# GRADING & EROSION CONTROL PLANS

## TRIVIEW METROPOLITAN DISTRICT NORTHERN DELIVERY SYSTEM BOOSTER PUMP STATION

EL PASO COUNTY  
APRIL 2023

- PROPOSED SEEDING/MULCHING AREA
- PROPOSED CUT AREA
- PROPOSED FILL AREA

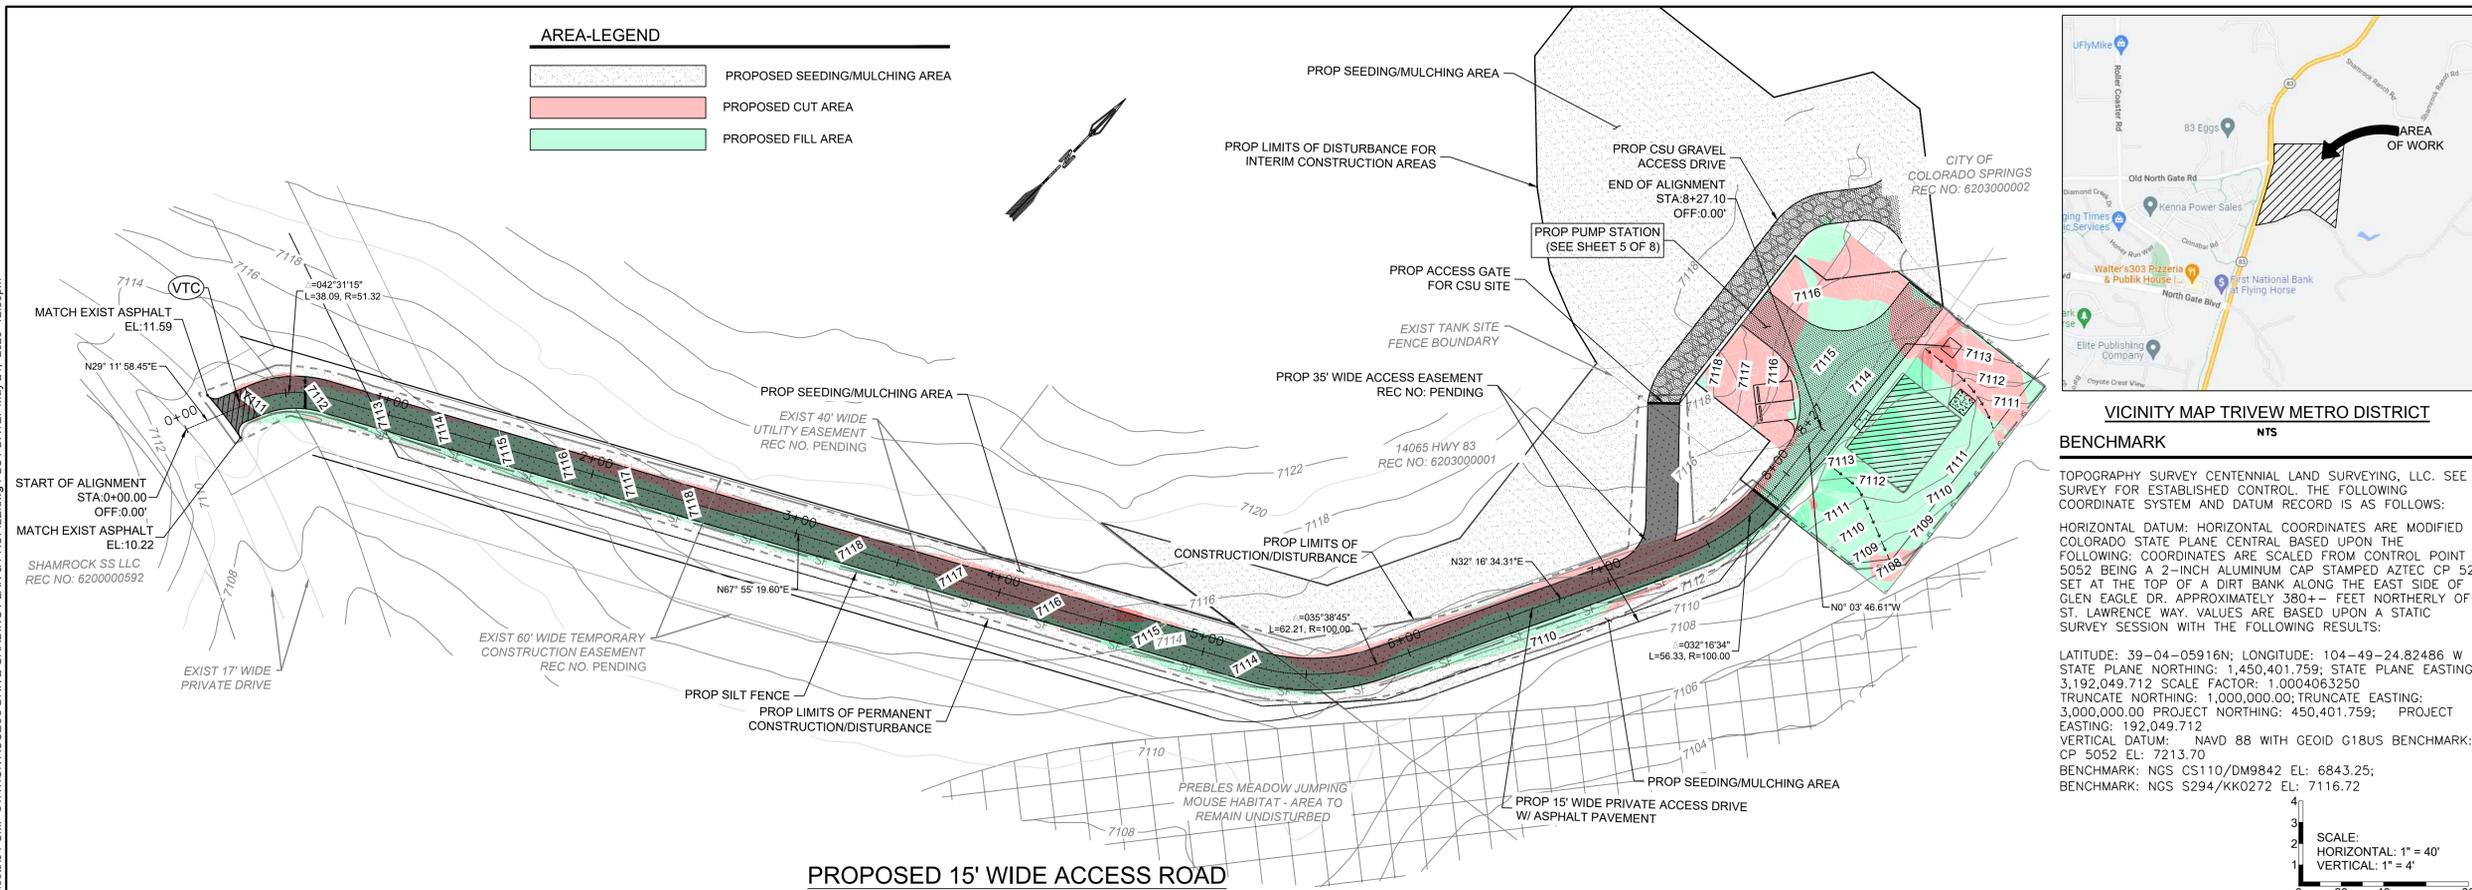
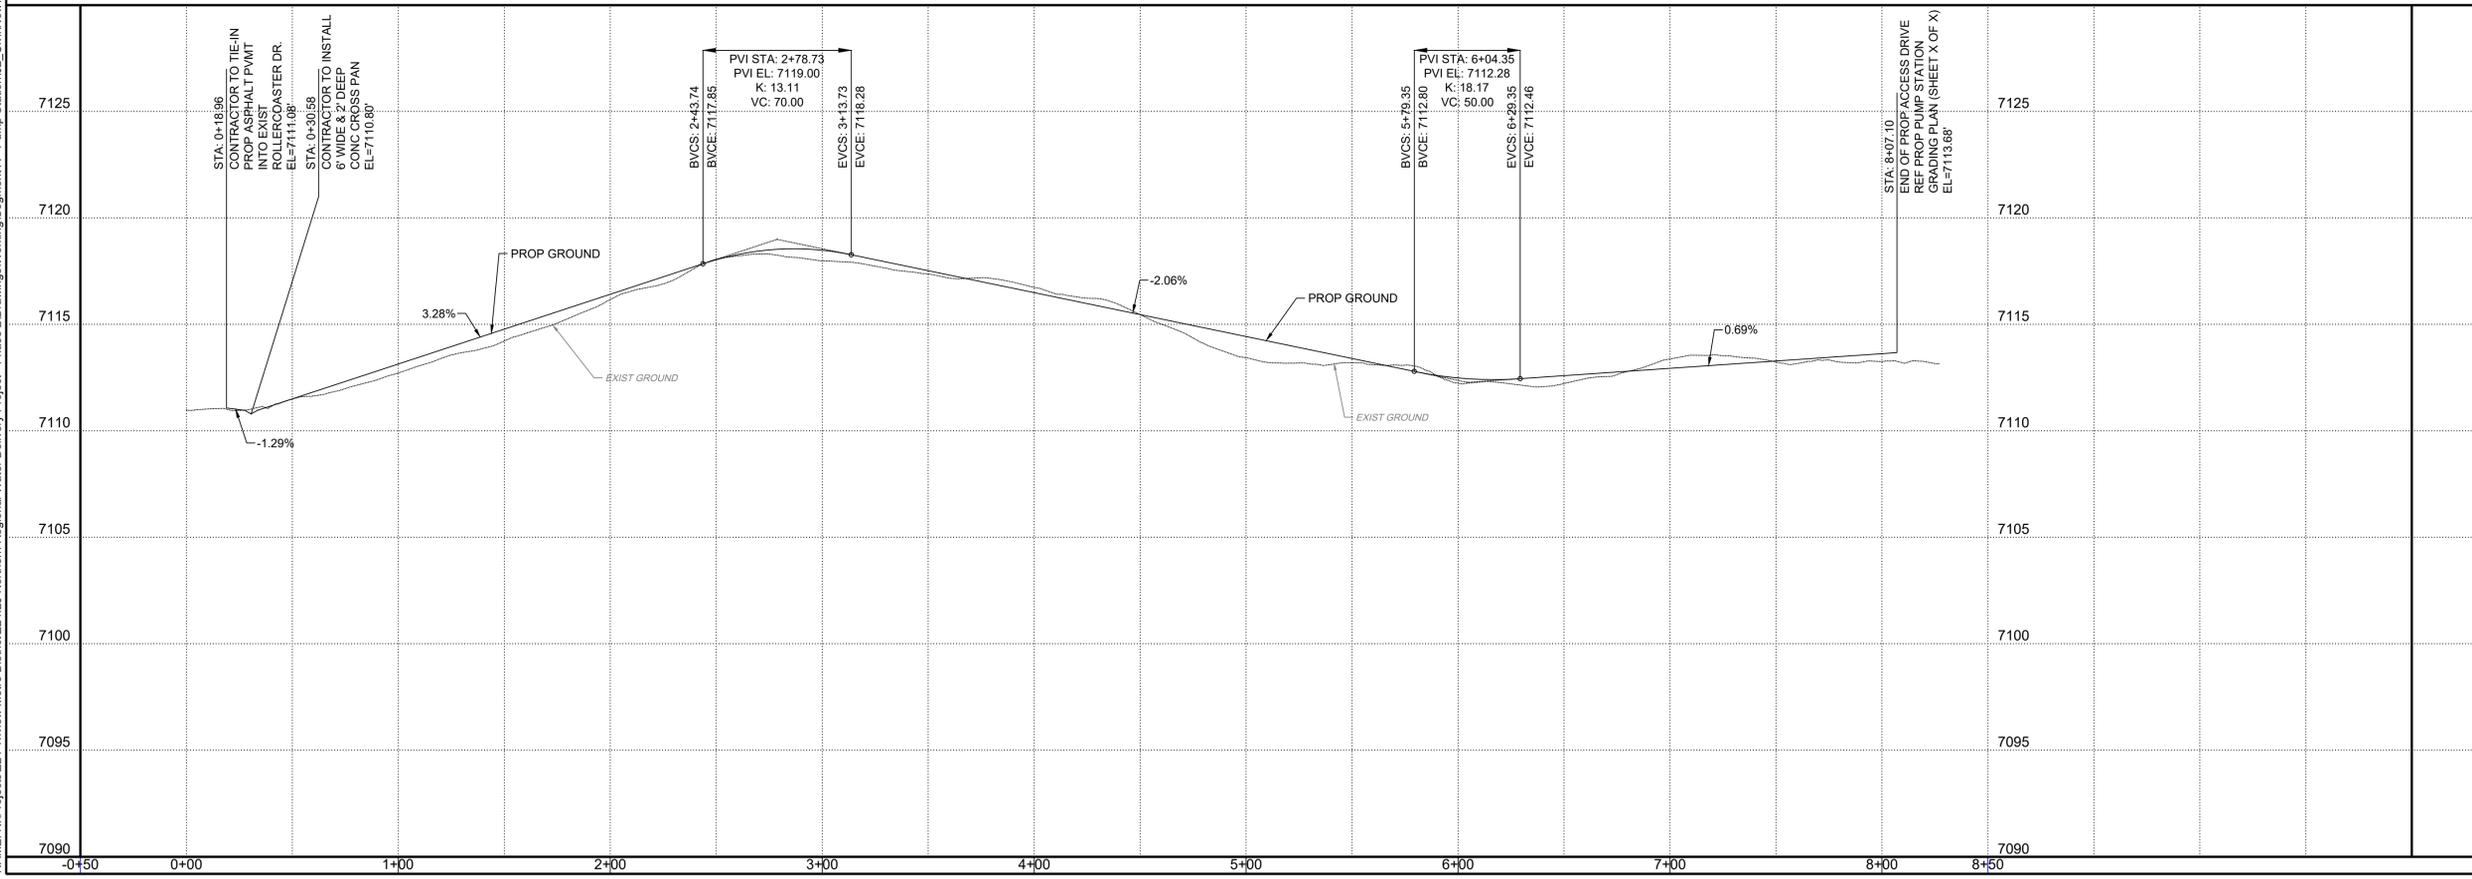
show all areas of cut fill  
show all areas of seeding/mulching  
unresolved

differentiate between the two flow arrows
